Ribble Valley Borough Council  
Housing & Development Control

Application no: **3/2019/0629**

Address: **20 Abbeyfields, Whalley, BB7 9RS**

Proposal: **One new dwelling (with room in roof space) and detached garage.  
Increase in residential curtilage**

Drawing title:
PROPOSED GARAGE SCHEME
DESIGN & STREET SCENE

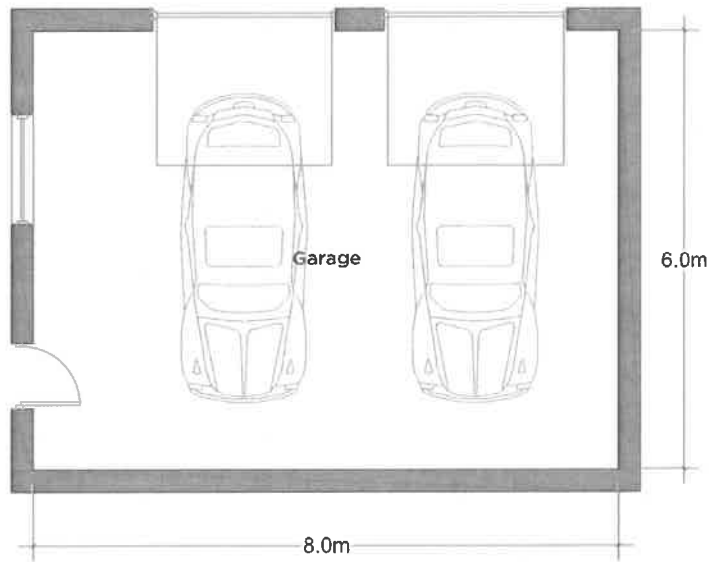
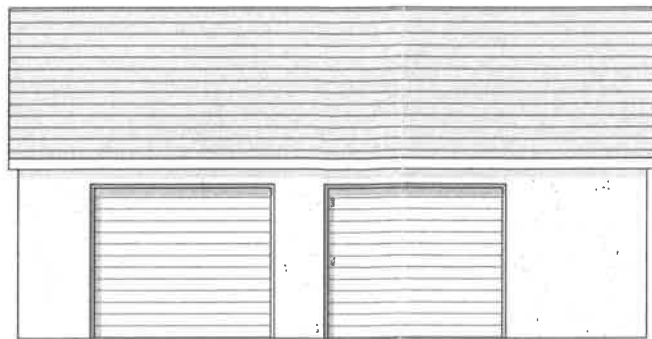
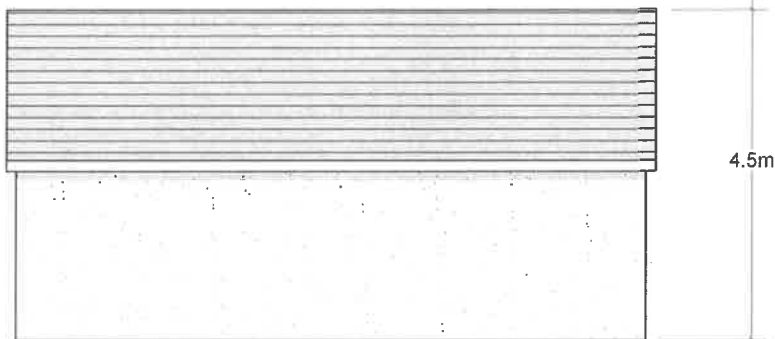
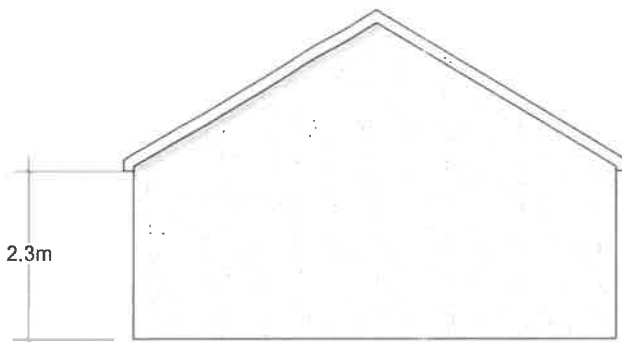
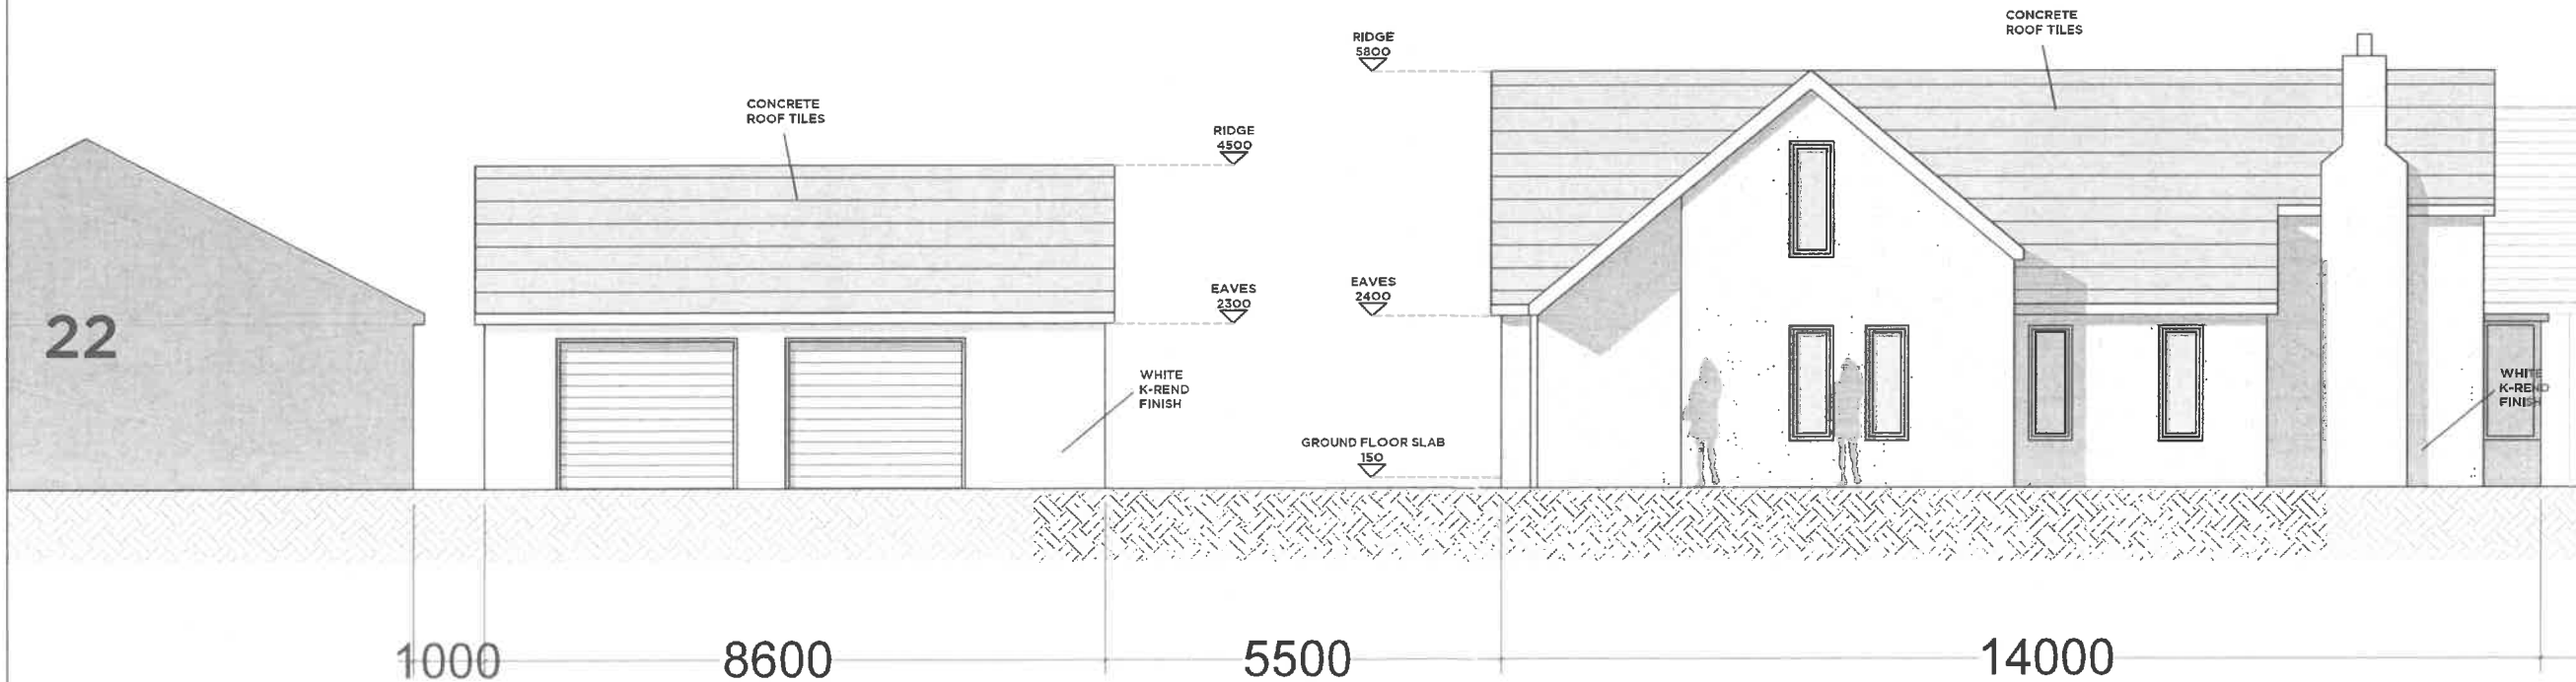
In accordance with the submitted plans, the proposed new access point in to the application site as proposed is to be formed using radius kerbs. However, the construction of a fully formed access point using radius kerbs at the proposed location is far too extensive for its intended purpose and therefore the installation of a dropped vehicular crossing should be implemented under section 184 of the highways act 1980.

The drive shall also be constructed with an approved bound porous surface material.

In accordance with the submitted plans, the boundary treatment hedge shall be permanently maintained at a height no greater than 900mm to aid visibility.

In accordance with the submitted application form there will be a requirement for four parking space. However, the proposal will require a parking provision of two parking spaces which can be accommodated for with the proposed double garage.
